STATE OF NORTH CAROLINA  
DEPARTMENT OF TRANSPORTATION

Subject: **Request for Individual Permit Modification** for NC 16 from north of NC 73 in Lincoln County to North of SR 1386 (St. James Church Road) in Lincoln County. Federal Aid Project No. STP-F-24-1(34) State Project No. 8.1830501. \$475.00 Debit work order 34383.1.4. TIP Project No. R-2206B.

Reference: USACE Individual Permit dated October 7, 2004, Action ID 200420899. NCDWQ Water Quality Certification dated September 21, 2004, Individual WQC No. 3476.

PROJECT REFERENCE NO.	SHEET NO.
R-2206B	EC-12/CONST. 12
R/W SHEET NO.	
ROADWAY DESIGN ENGINEER	HYDRAULICS ENGINEER
CONST. REV.	
R/W REV.

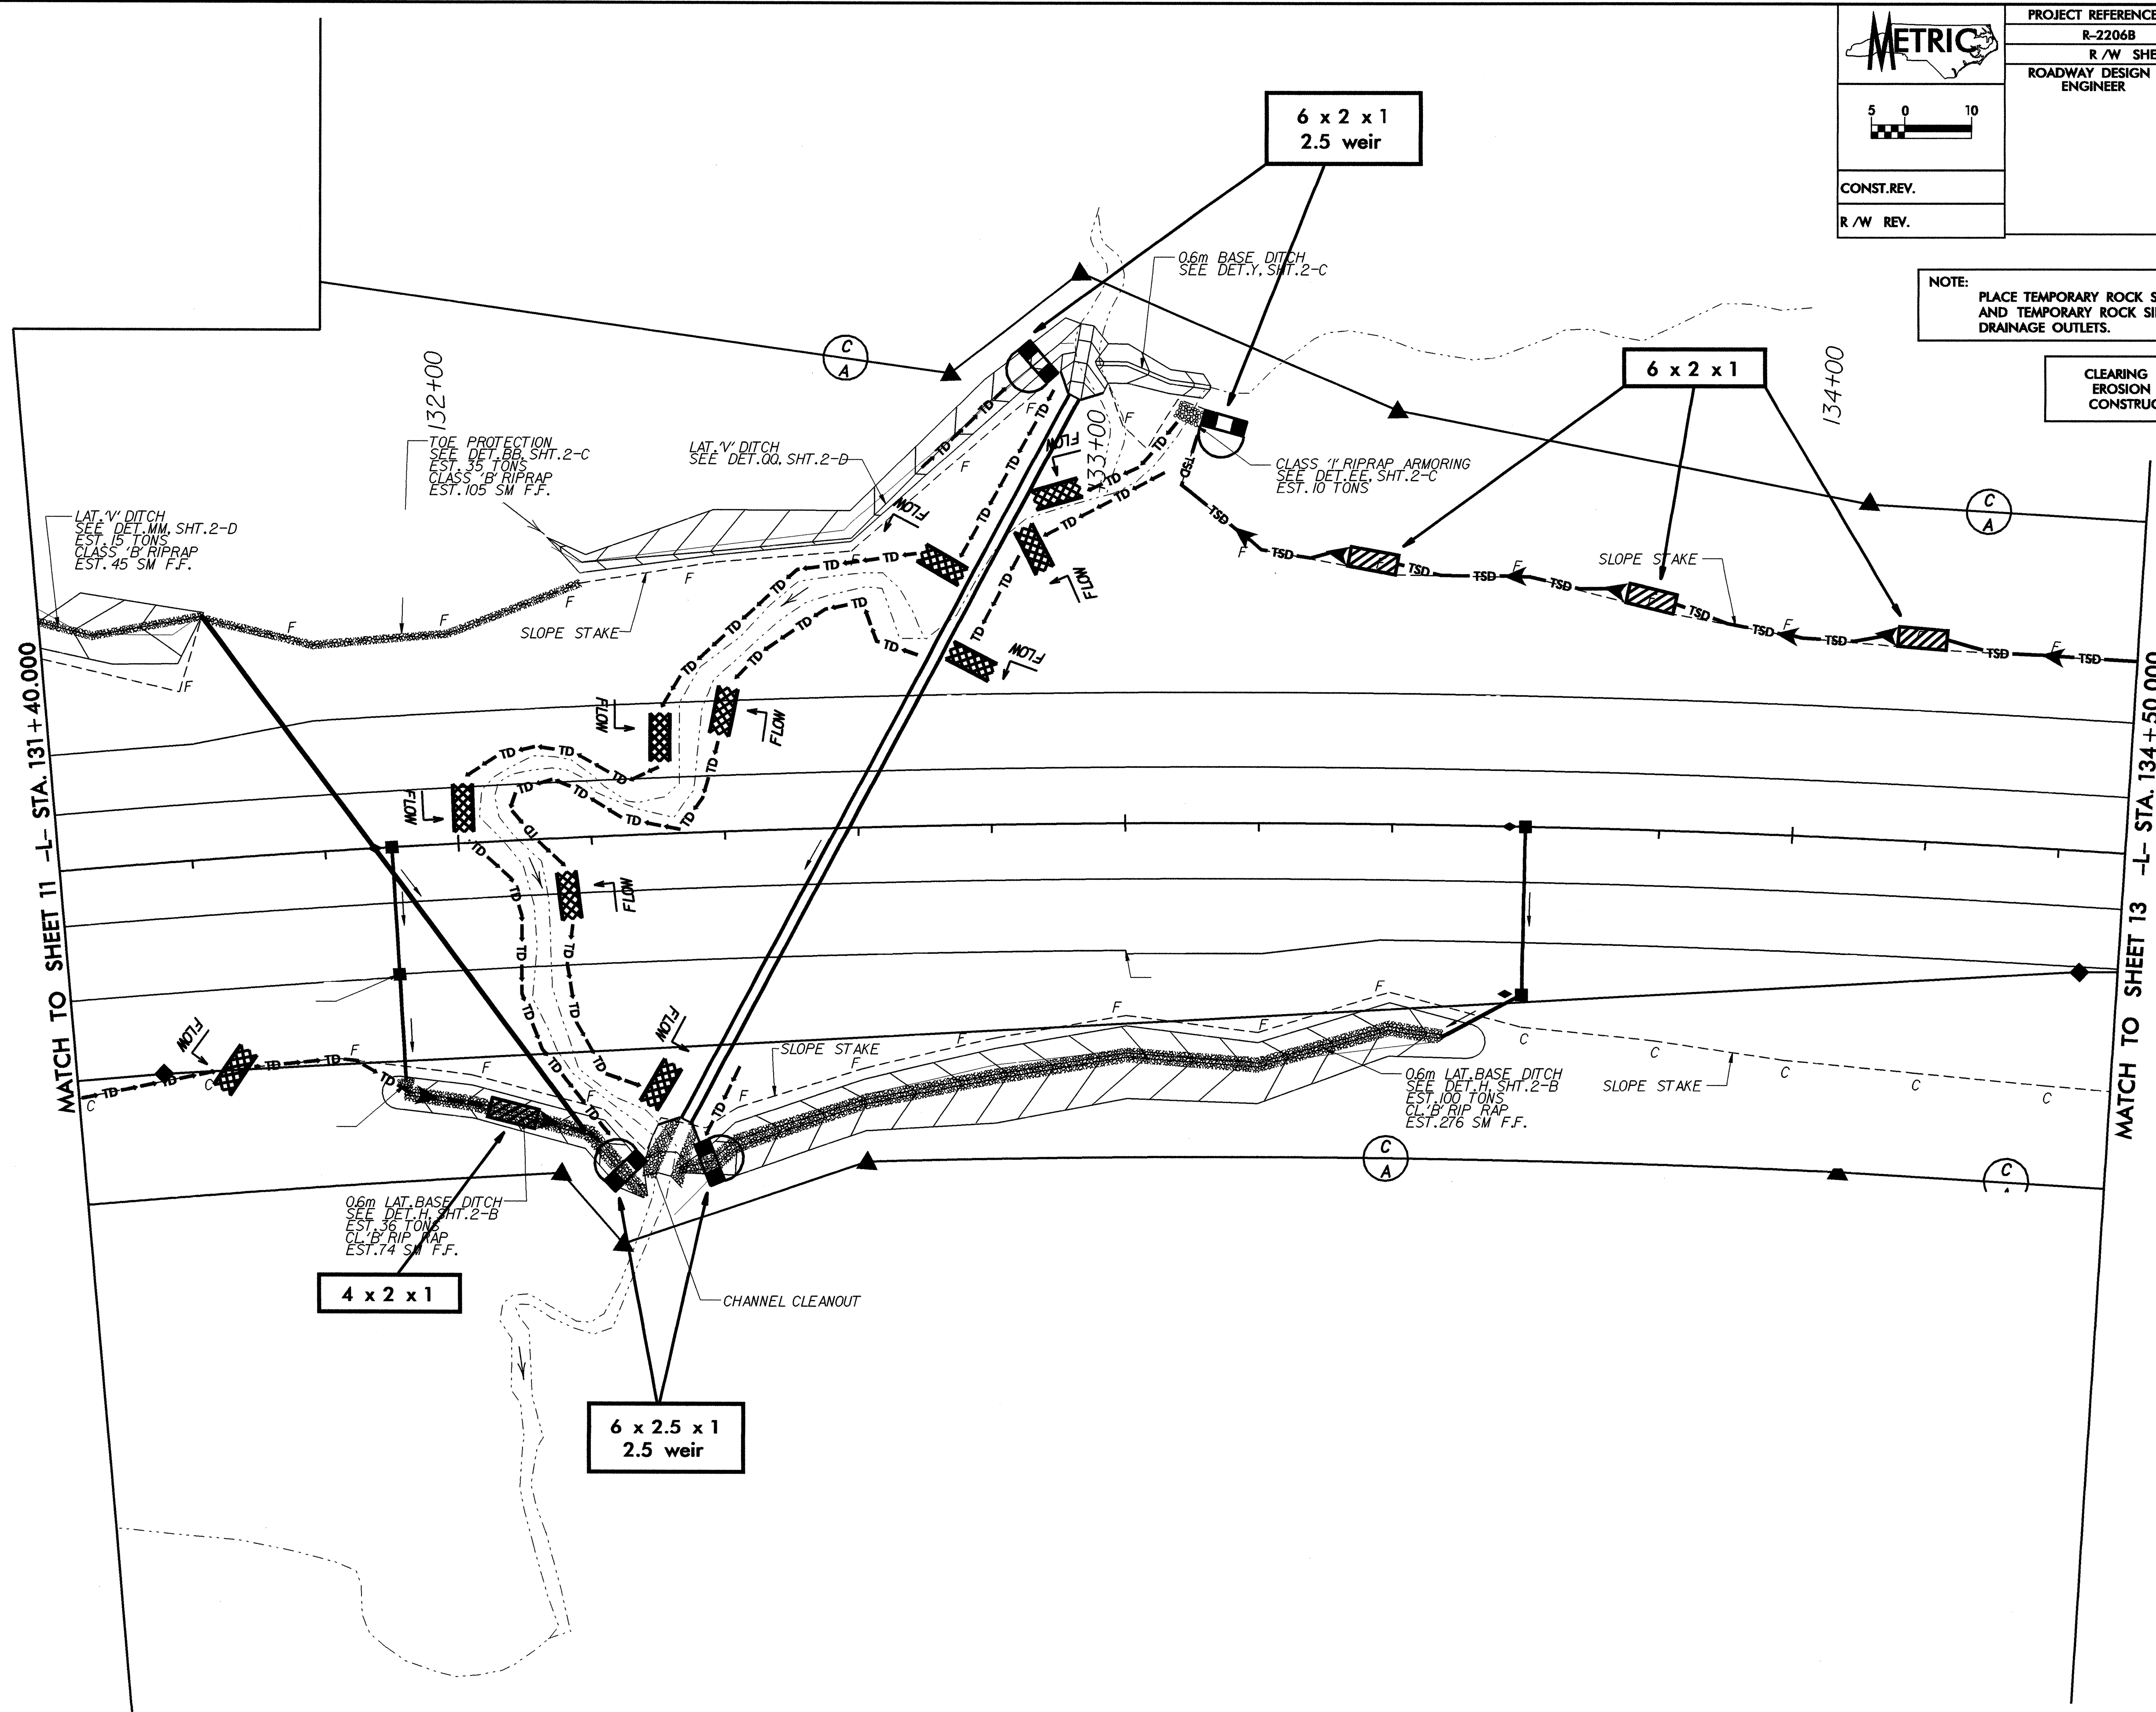
Permit Site 4B is a single barrel box culvert on a UT to Forney Creek. Due to the low flow and low bed load carrying capacity of the subject stream, a 12-16 inch head cut has developed and is moving upstream. A smaller UT intersects the subject stream at the head cut and has developed its own head cut. NCDOT proposes to place a cross-vane weir on the main stem and a boulder in the smaller UT. These measures are proposed to act as grade control and allow aquatic passage.

PROJECT REFERENCE NO. R-2206B	SHEET NO. 11
R/W SHEET NO.	HYDRAULICS ENGINEER
ROADWAY DESIGN ENGINEER	SEAL
022609	14160
02/24/04	02/24/04
WILBUR SMITH ASSOCIATES P.O. BOX 2478 RALEIGH, N.C. 27602-2478	TRANSITE CONSULTING 1300 PARKWAY DRIVE, SUITE 9-10 RALEIGH, N.C. 27609

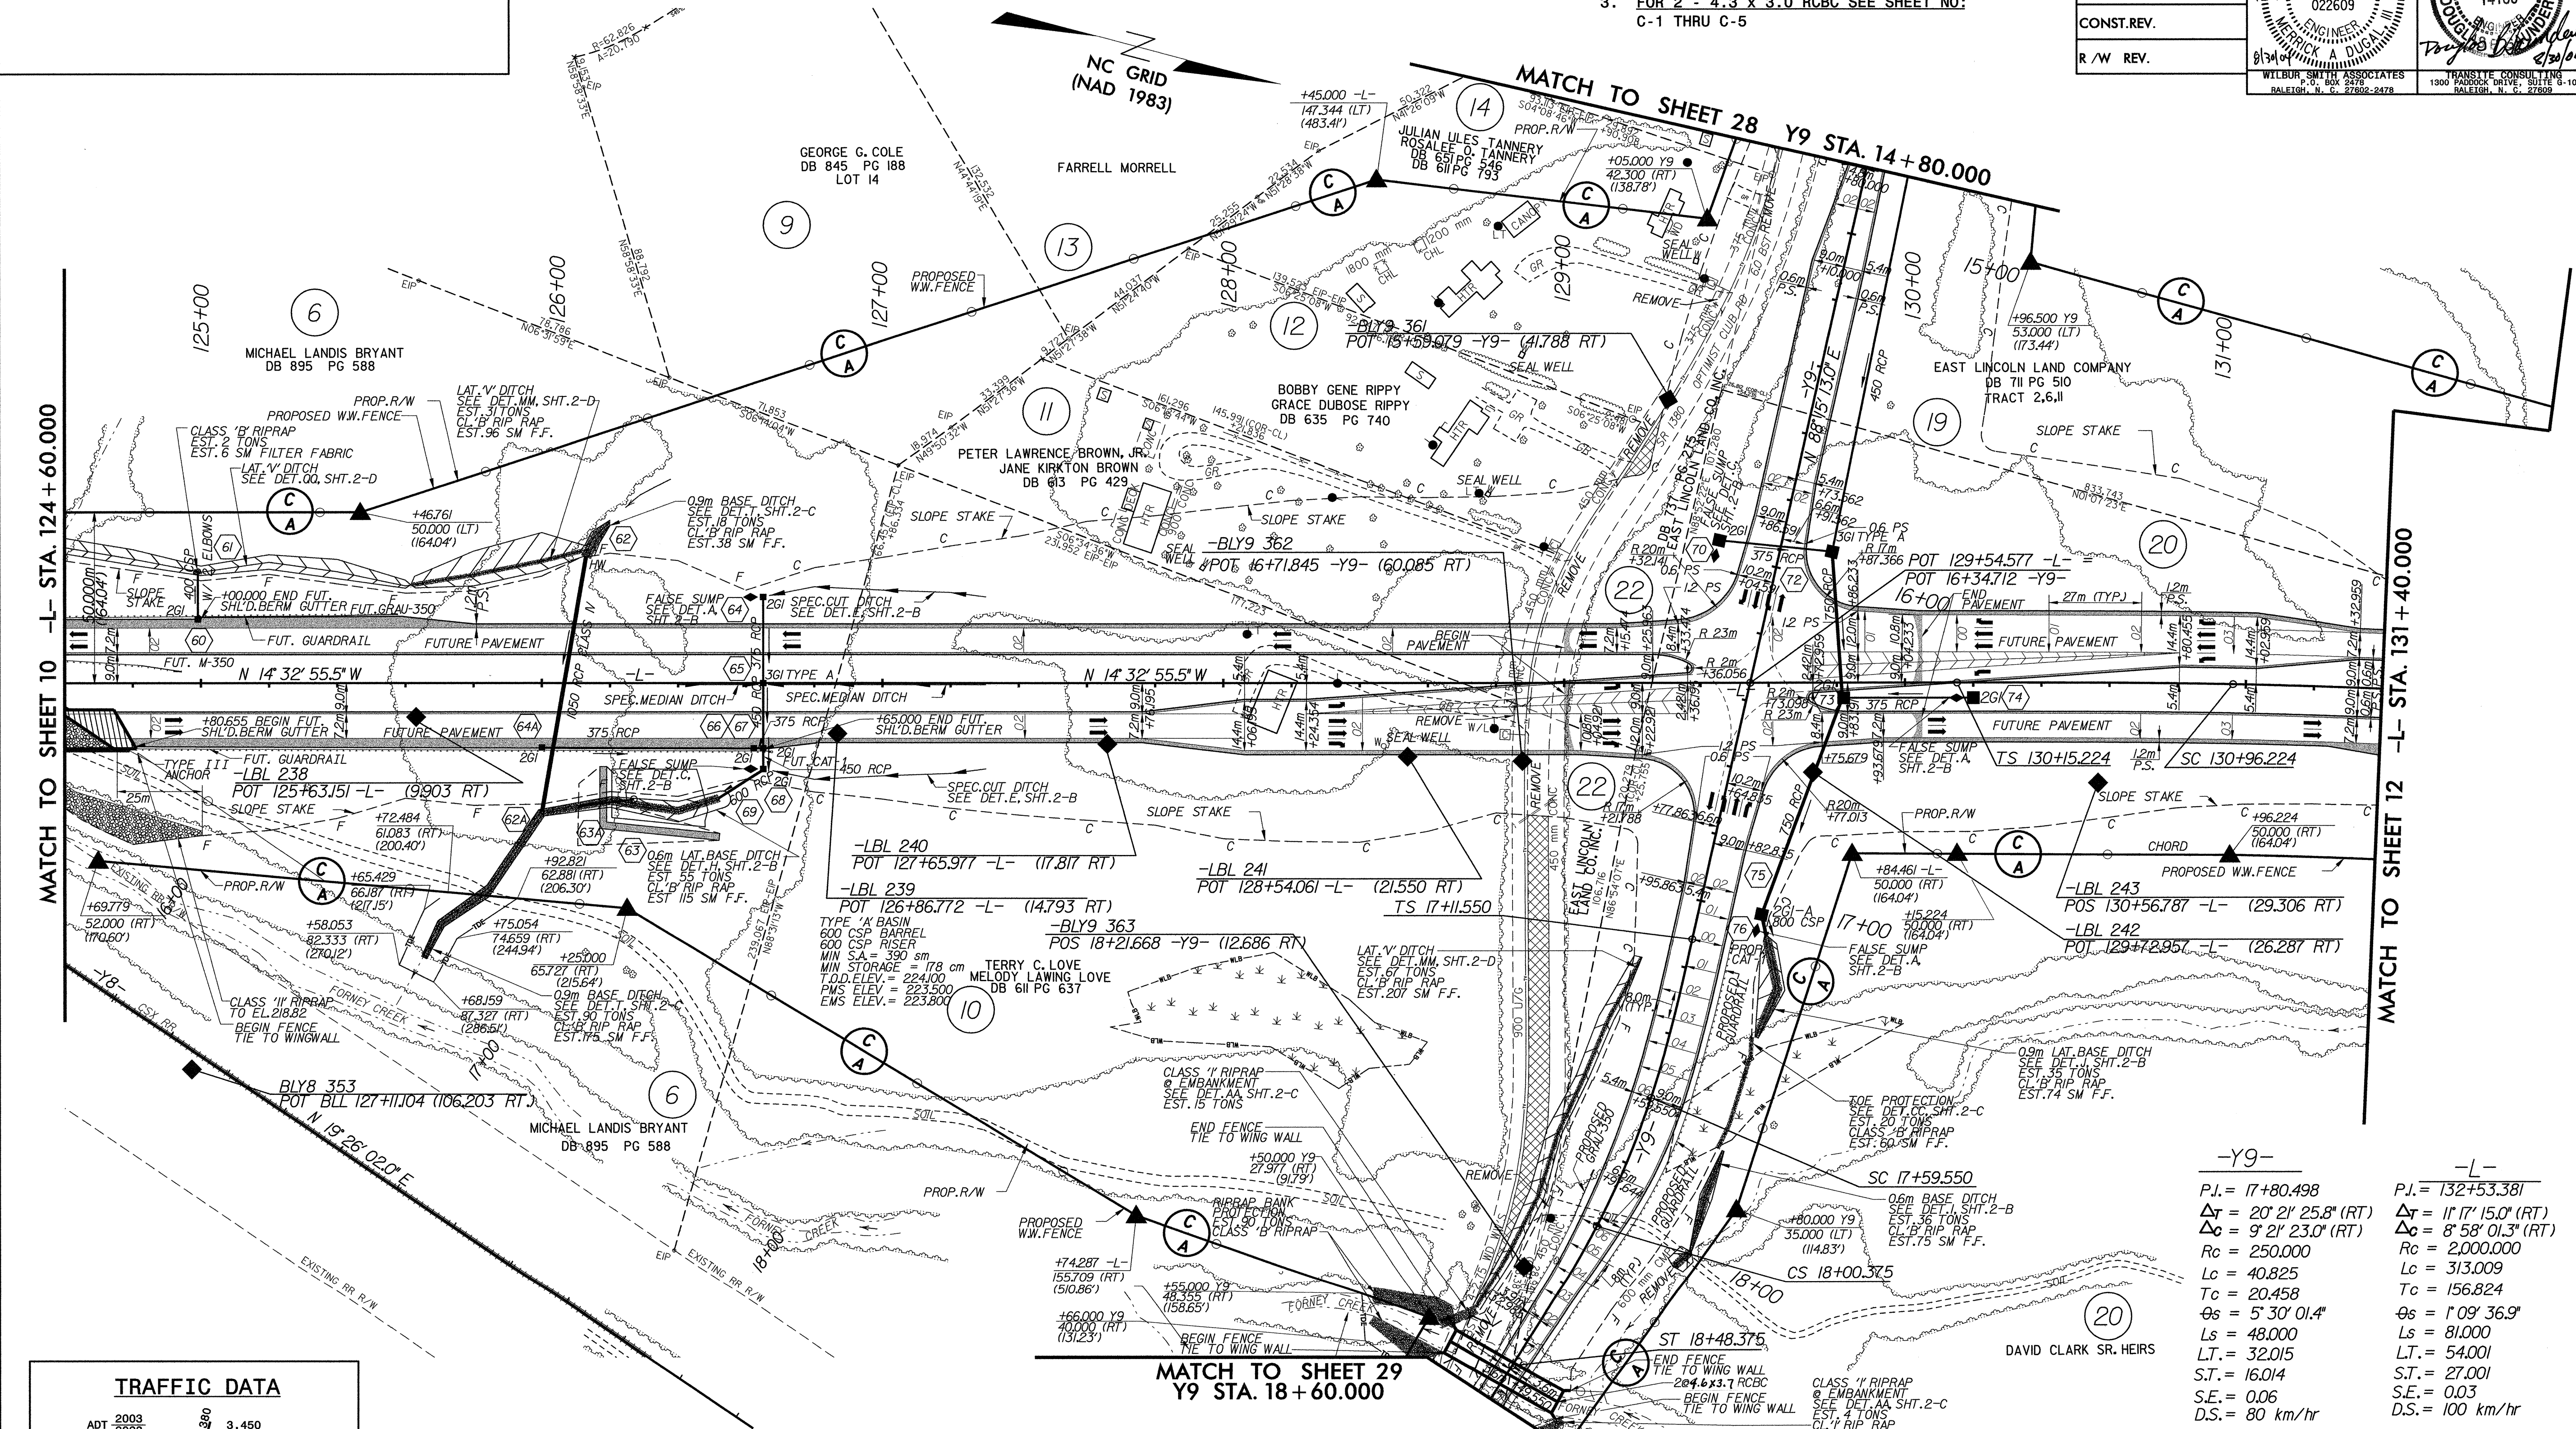
Permit Site 14B is a double barrel box culvert on Forney Creek. A small, unnamed tributary intersects Forney Creek approximately 25 feet upstream of the wingwall for the culvert. The banks of the unnamed tributary were armored with riprap keyed in from the toe of the stream bank to the average high water mark approximately two feet above the surface of the water. This is an after the fact notification. Action was taken to prevent the stream from migrating downstream and discharging into the wingwall of the box culvert. The amount of permanent channel impacted is 75 feet.
